Town of Addison
Summary of Engineering Revision Comments

Development: Galaxy FBO

Town Project #:19-09D

SHEET NUMBER
C00.06

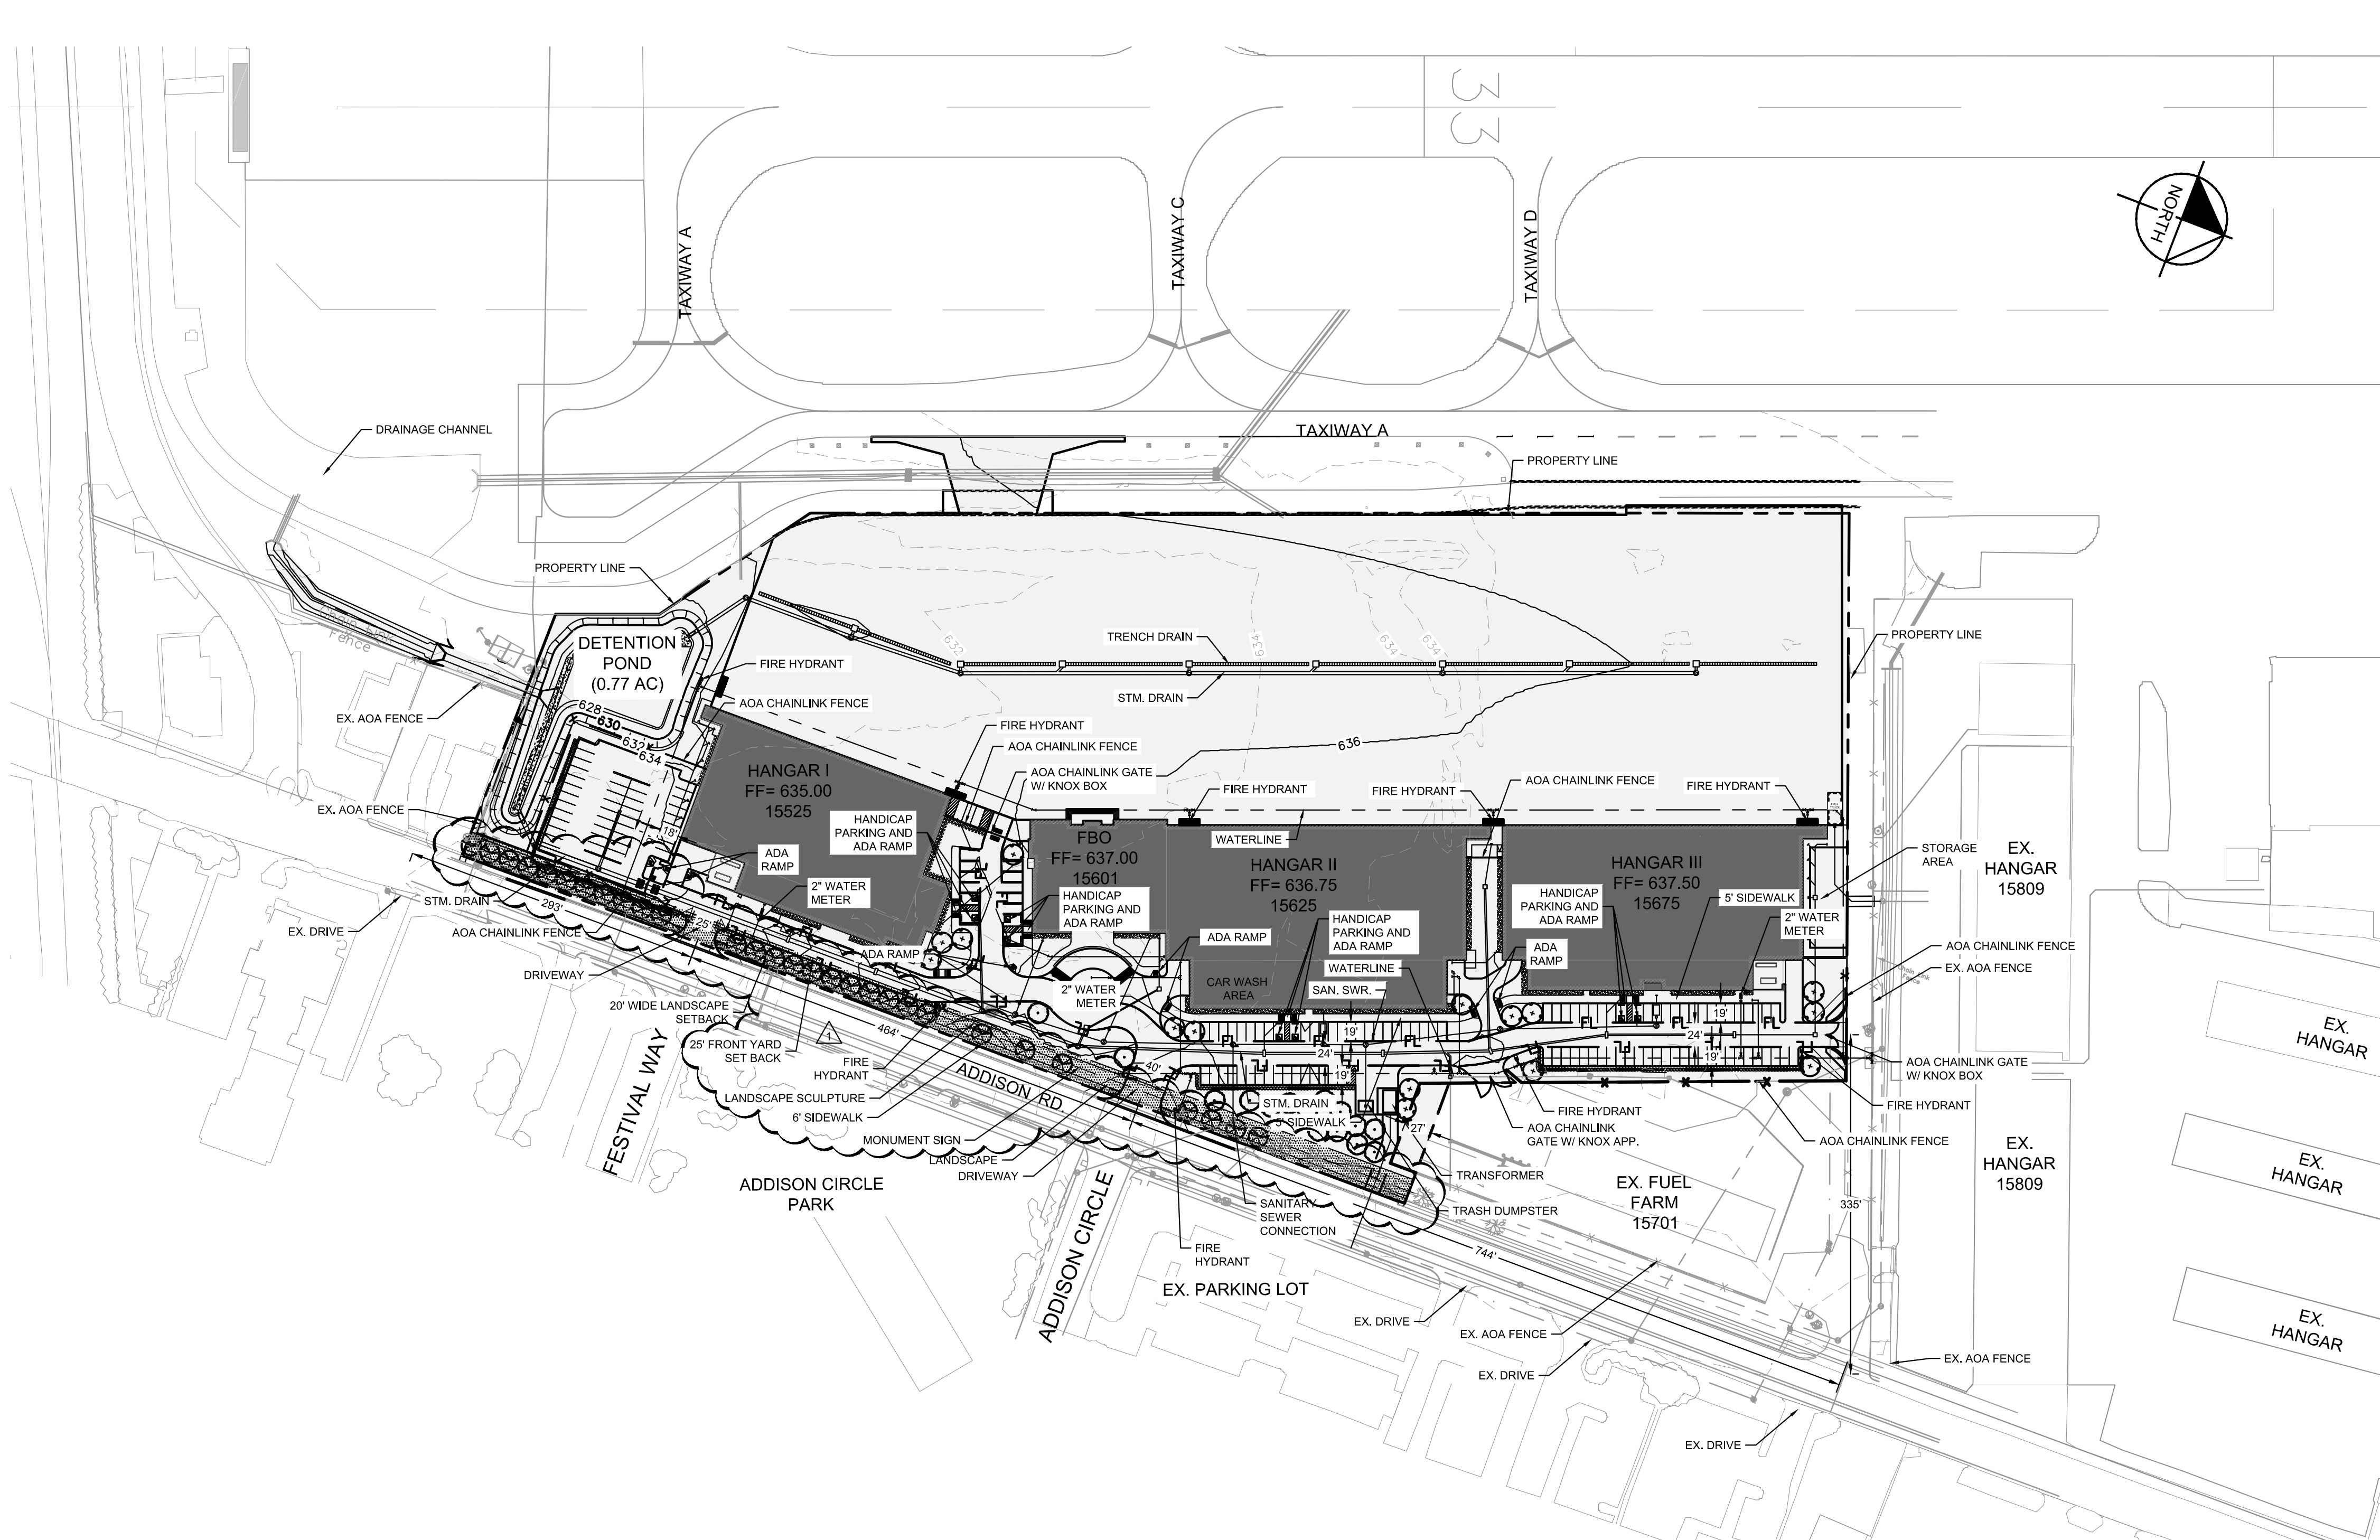
Revision No.	Date	Page No.	Comments	Reason for changes
ASI-C005	8/7/2020	C00.06	Removed the ornamental fence that was previously proposed along Addison Road since that is not allowed within the 25-foot front yard setback, and moved the chain link fence on the east side of the parking area at the south end of the site outside the 25-foot front yard set back. This change required the deletion of one parking stall in the south parking area.	
ASI-C005	8/7/2020	C03.01	Added callouts for the removal of the existing AOA Fence between the proposed detention pond and Addison Road so that short segment of the AOA fence can be reconstructed outside the 25-foot front yard setback as part of the scope of this project	
ASI-C005	8/7/2020	C05.01	Updated the east curb line of the parking area at the south end of the site so the fence on the east side of that parking area could be moved outside the 25-foot yard setback. Also added a curb slot to allow the sliding gate to role in and out.

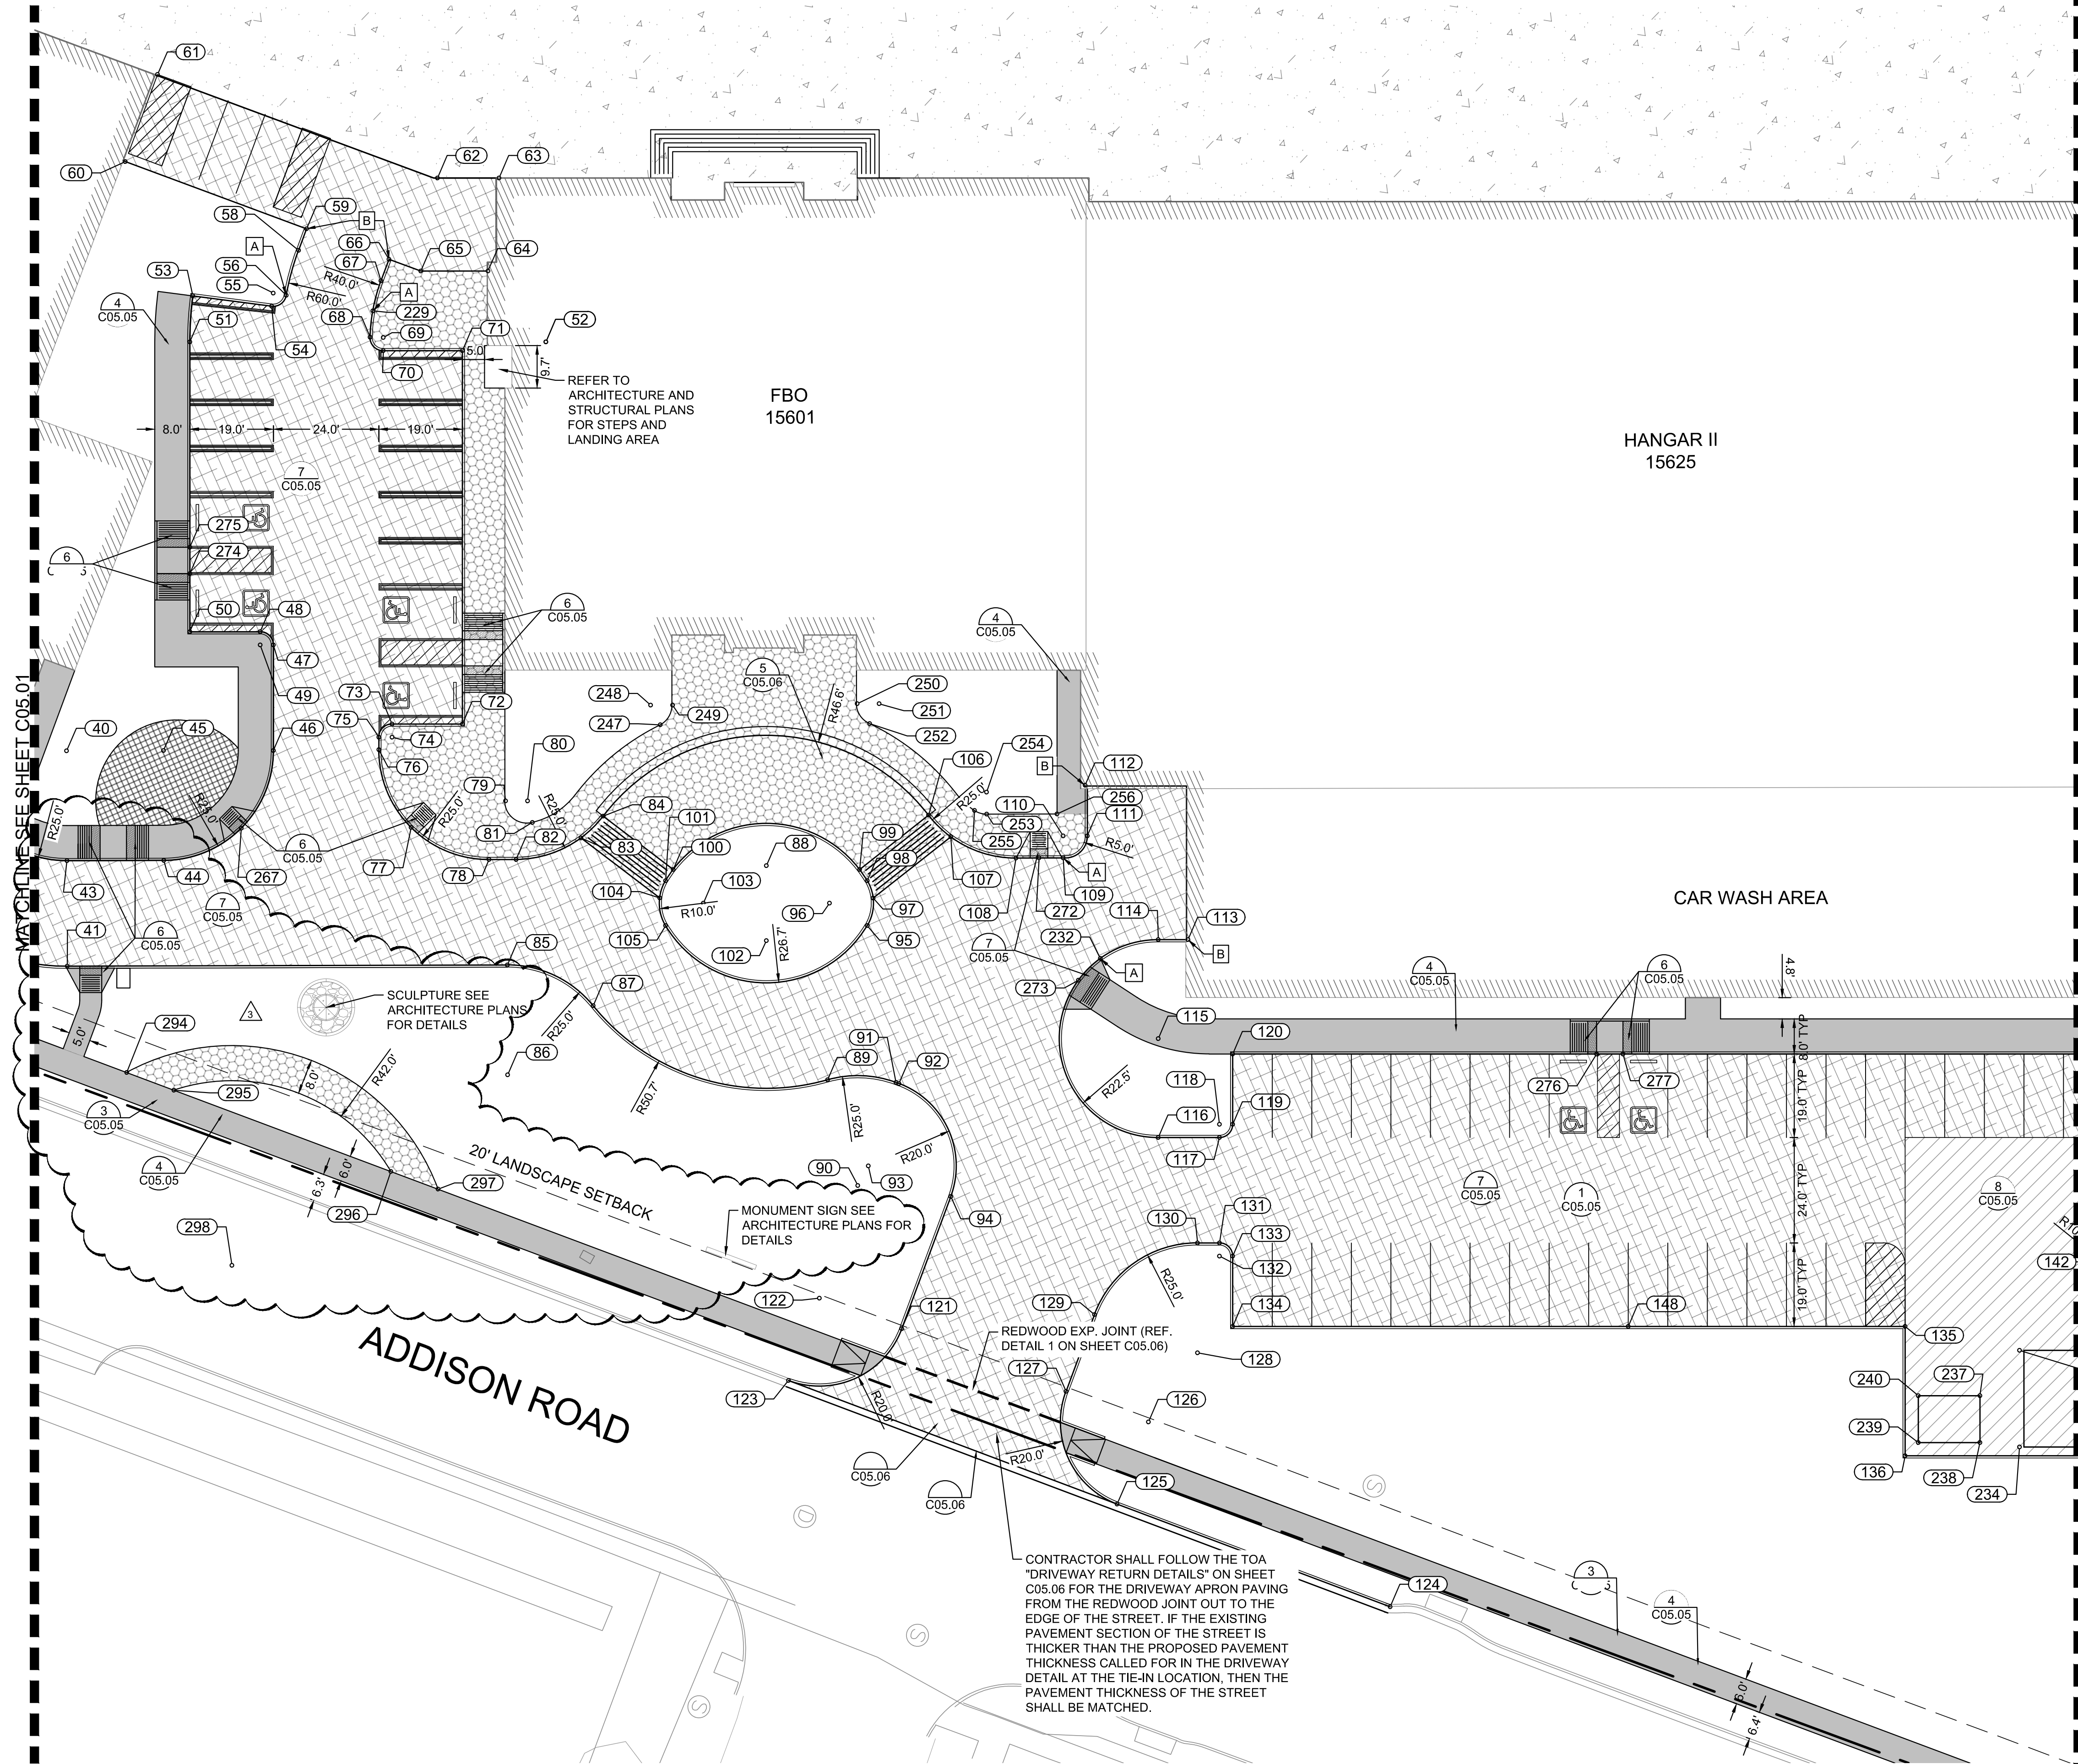
ASI-C005	8/7/2020	C05.02	Added the public art plaza area.	
ASI-C005	8/7/2020	C05.04	Adjusted point number 11, 19, 20, 21, 22, 23, and 24. Also added point 280 - 298	
ASI-C005	8/7/2020	C07.01	Adjusted joint spacing based on the modification to the east curb line of the parking area at the south end of the site.	
ASI-C005	8/7/2020	C09.01	Adjusted elevations based on the modification to the east curb line of the parking area at the south end of the site.	
ASI-C005	8/7/2020	C09.02	Added elevations on the sidewalk and ramps that were added/adjusted around the public art plaza.	
ASI-C005	8/7/2020	C10.05	Adjusted elevations based on the modification to the east curb line of the parking area at the south end of the site.	
ASI-C005	8/7/2020	C10.06	Adjusted elevations on the sidewalk and ramps that were added/adjusted around the public art plaza.	
ASI-C005	8/7/2020	C16.04	Removed one parking stall for the parking area at the south end of the site.
